Dear DPIE Staff,

The Biodiversity Assessment Report attached to the Environmental Impact Statement for the M1 extension to Raymond Terrace concluded, 'that the project is not expected to significantly impact the movements of koalas and no targeted connectivity measures are required for koalas.' However, a review of the Environmental Impact Statement with local knowledge would suggest that koalas may move away from the proposed Motorway. Therefore, this submission will outline strategies to counteract the project's potential impact on koalas in the Heatherbrae and Raymond Terrace areas.

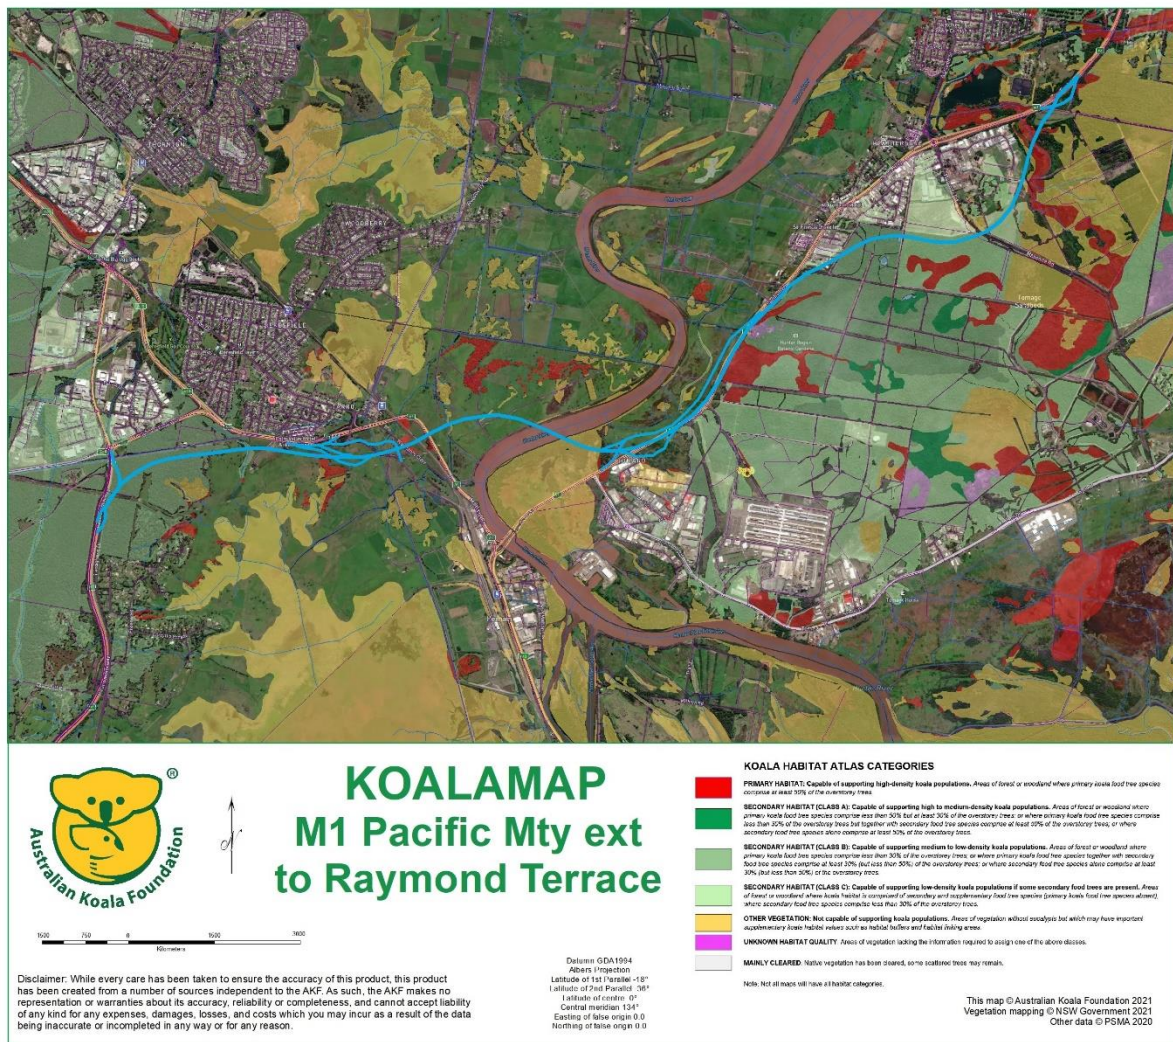
Preserving vegetated corridors close to the impacted areas will ensure the genic biodiversity of fauna and flora impacted by the project's footprint. The Environmental Impact Statement reported that NSW Transport is seeking more land to offset the loss of habitat. There are two pieces of land connected to the construction footprint with remnant vegetation and histories of koala sightings that could be used as offsets. One of these properties is owned by Transport, and the other is a private property on the market. Please view Figure 1 for the locations of each property in the attachment window. Securing this acreage for conservation will protect koalas from habitat loss.

The aerial photograph of the site for the Raymond Terrace Interchange shows a sectioned off piece of land with diagonal stripes. This land is attached to the Pacific Highway. The property has been described as '*project land owned by Transport*'. (Figure 14-6, Map 8 of 8, page 28, Chapter 14, EIS M1 to Raymond Terrace). The land is divided into three lots. The DP number for the most considerable portion of land is DP846612, Lot 14. The DP number for the smaller pieces of land is DP 840996 Lots 14 and 15.

If NSW Transport does not have a conservation plan for this land, one must be implemented. The northwest corner of this property is adjacent to the Grahamstown Canal Bridge fauna underpass for the Pacific Highway. This underpass connects to the primary koala habitat through Elizabeth Reserve and along Grahamstown Drain. See Koalamap 2021 in Figure 2 in the attachment window. Furthermore, there are two clusters of *Eucalyptus Parramattensis* subsp. *decadens* growing on this property in the M1's footprint (Appendix I, Figure 4-5, map 5 of 5 pages 156). There may be more clusters of this threatened koala food species on this property, which will increase its conservation value.

The address of the land which is on the market is 6c Elizabeth Avenue, Raymond Terrace, DP 853008, Lot 42. It is 8.44 hectares and zoned as a rural landscape (Commercial Real Estate). Figure 3 in the attachment window shows this property and the adjacent habitat. The northeast corner of the property borders a forest that connects to the south side of the Grahamstown Drain fauna underpass. The boundaries of this property form a triangle. The eastern side of the property joins the Pacific Highway. The north side connects to Elizabeth Reserve. Figure 3 has a white circle around this Reserve. The Muree Golf Course is on the north side of Elizabeth Reserve. Figure 3 has a blue boundary around the golf course. In addition, Boomerang Park and Pioneer Hill Cemetery connect to the west edge of the Golf Course. The above sites contain preferred koala food trees.

The preservation of native vegetation on these two properties will ensure koalas have a viable corridor from the east and west side of the Motorway. Furthermore, this will allow the recolonisation of koalas into Raymond Terrace.
